Appendix 8 – Summary of Changes

ACP RFI Document Changes

GORTLOUGHRA WIND FARM, CO. CORK.

Title
Internal Cable Trench Details

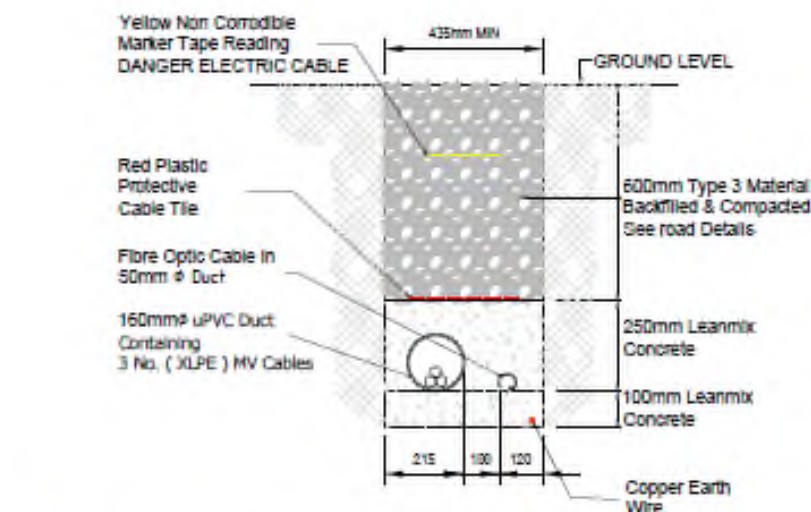
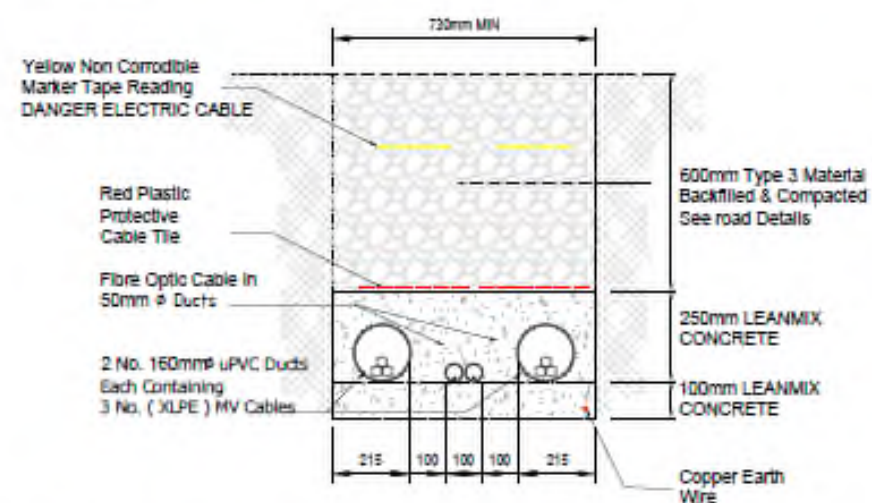
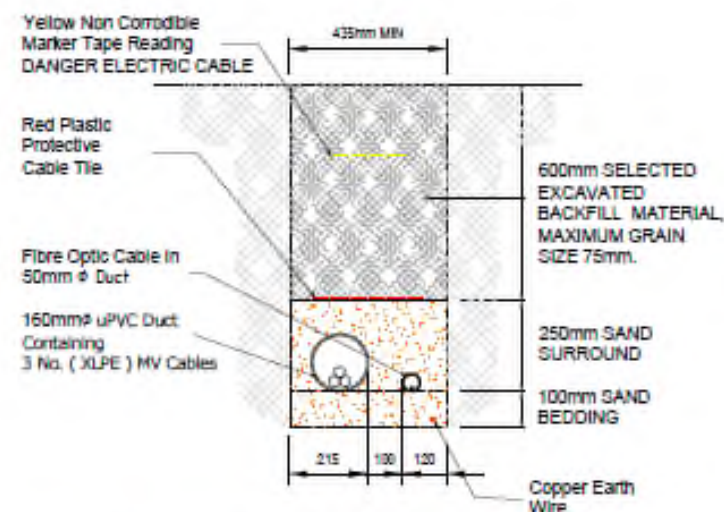
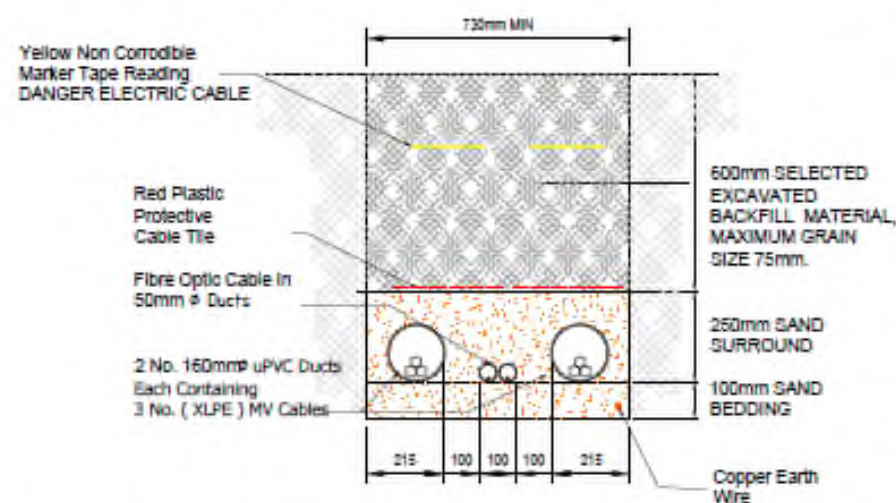
EIAR Element	Section Updated	Details of Updates
Figure 2.9: Internal Cable Trench Details		
Figure 2.10 Grid Connection Route		
Figure 2.11: Drainage Details		
Figure 2.11 b: Drainage Details		
Figure 2.12: Drainage Details		
Figure 2.13: Drainage Details		
Figure 2.14: Construction Compound
